Approval of details reserved by condition imposed under AL/20/21/PL relating to condition 22-details of required fire hydrants.

Land At Wings Nursery Lidsey Road Woodgate PO20 3SU

Arun District Council have decided to **REFUSE details reserved by condition for the following reasons:**

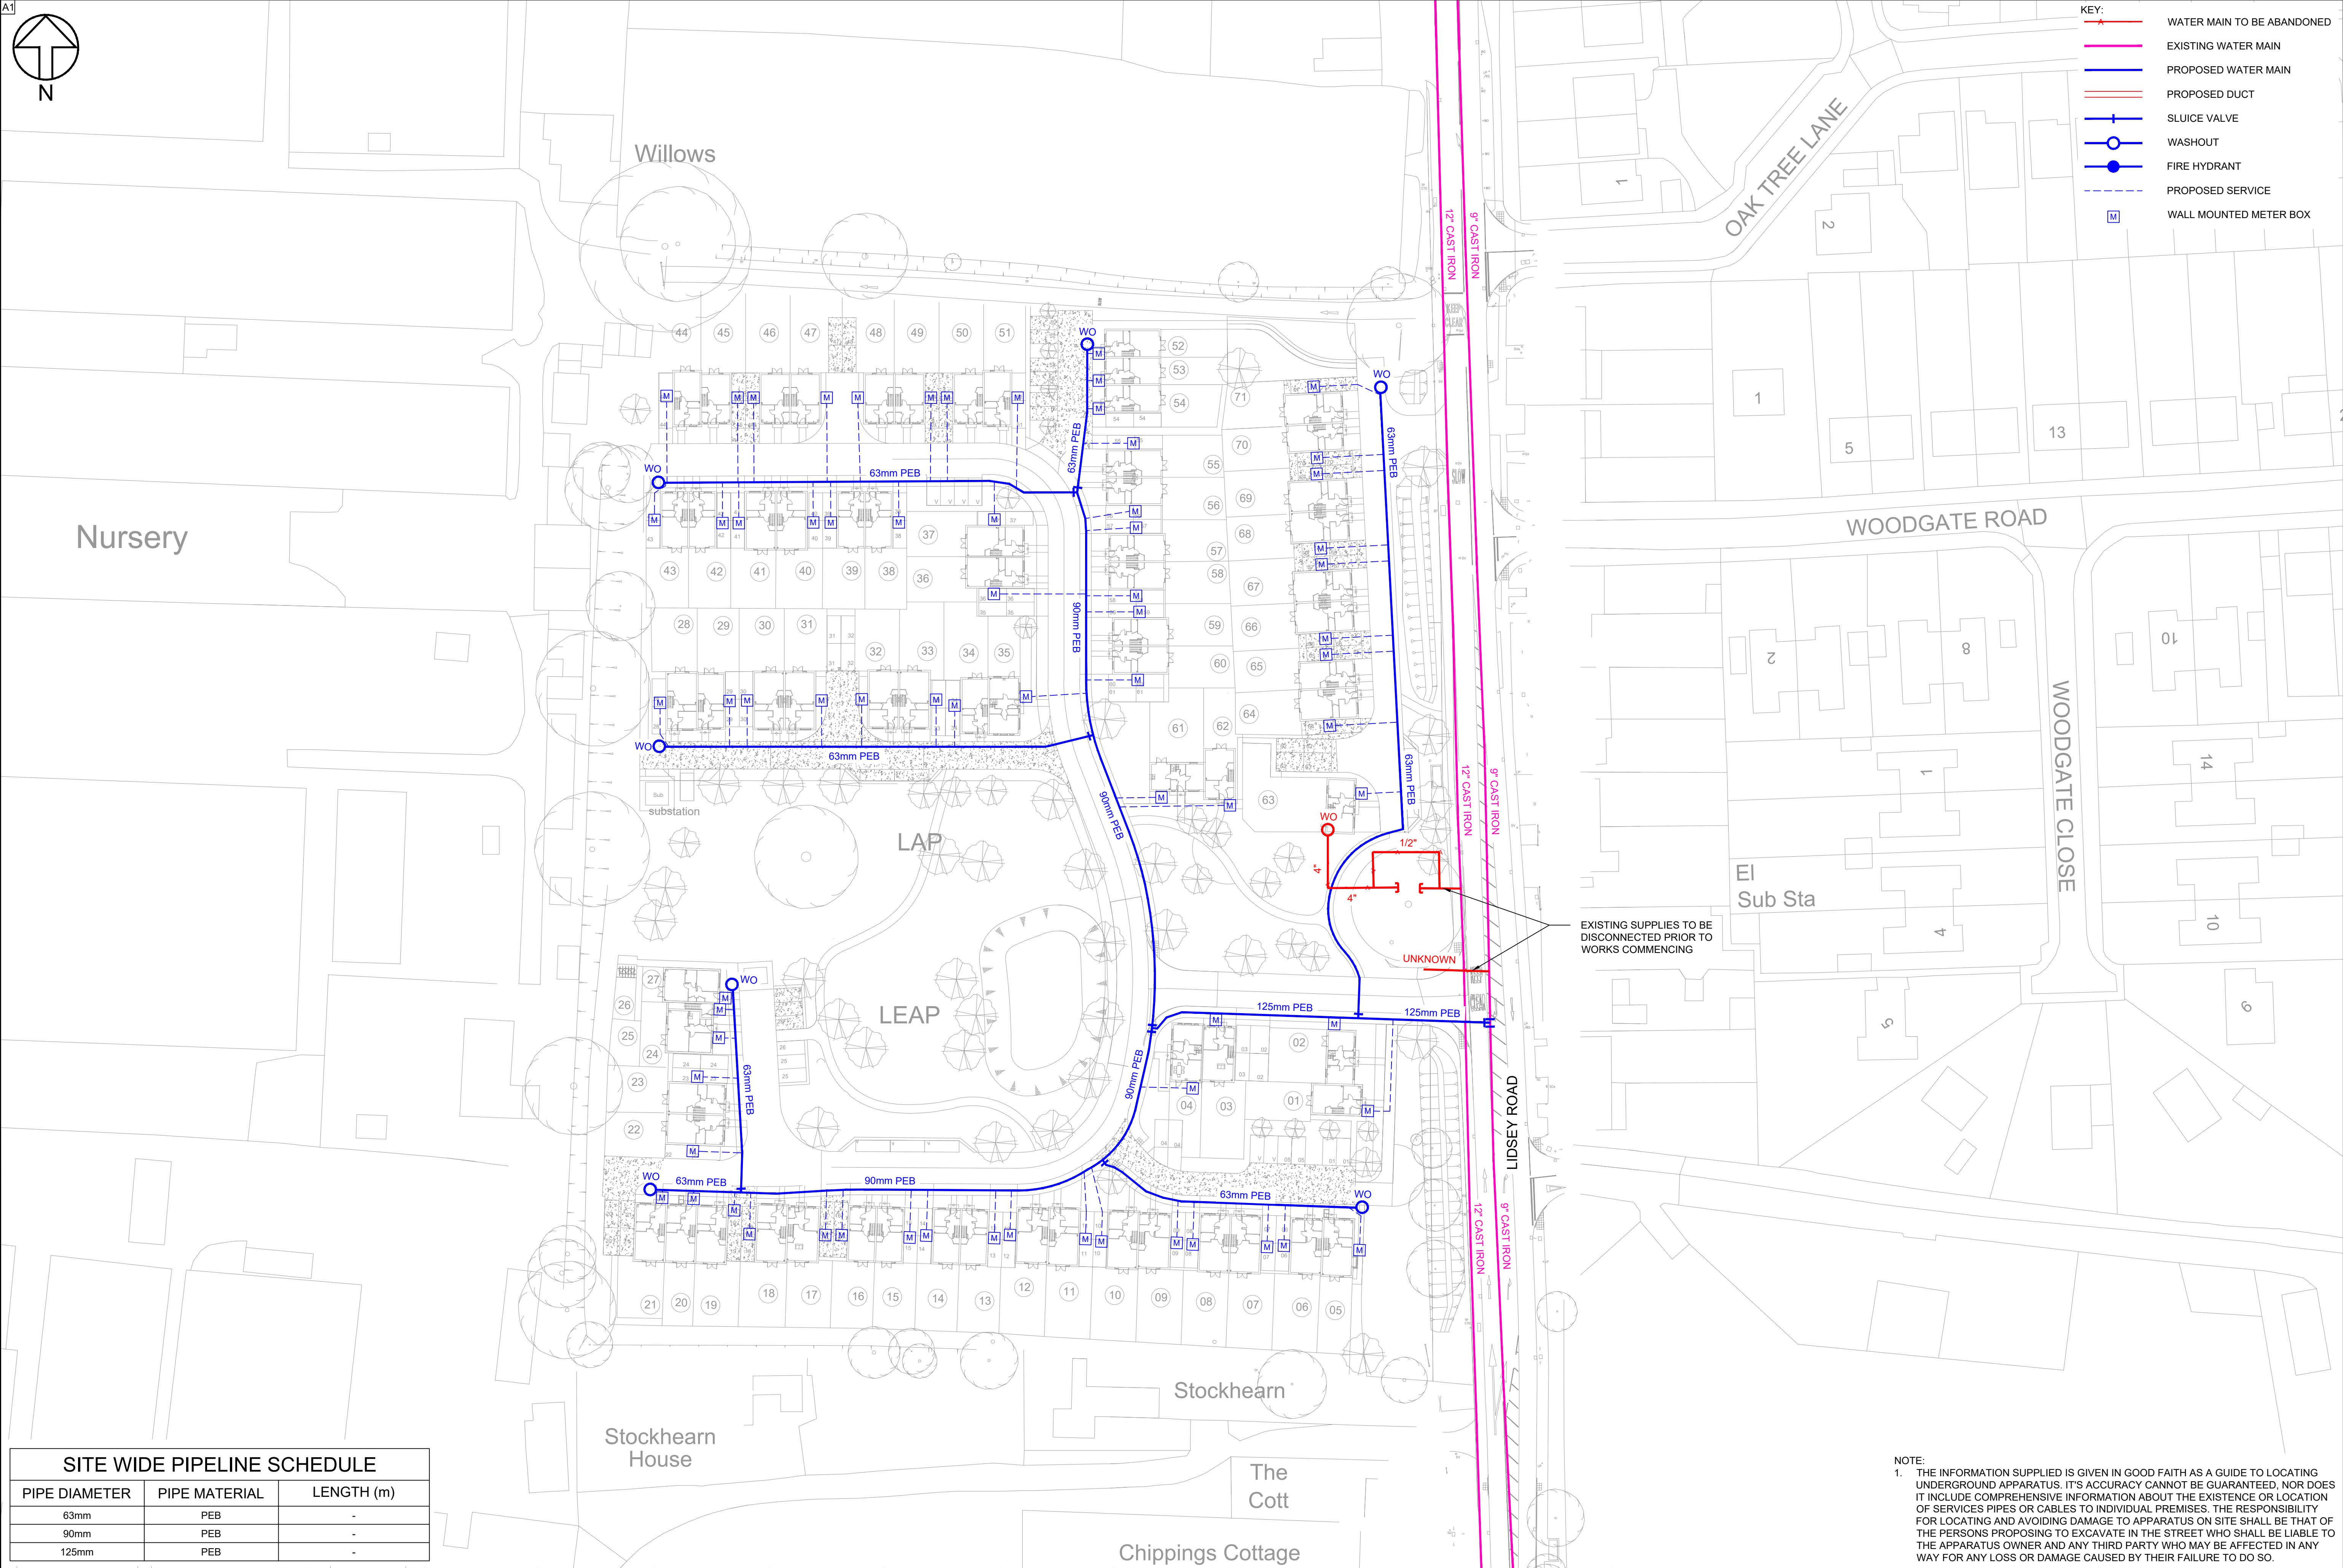
"The water main plan submitted does not have any fire hydrant locations indicated and all the wash out hydrants are on 63mm mains. The minimum mains size for a fire hydrant is 90mm, so the mains indicated on the plan is not suitable for supplying any fire hydrants, the mains size is too small. This was consulted on with the Water Supply and four fire hydrants were required."

This was put to you on the 1st April 2022 but no response or amendments have been received. The Council is unable to discharge this condition at the present time and you will need to make a revised submission.
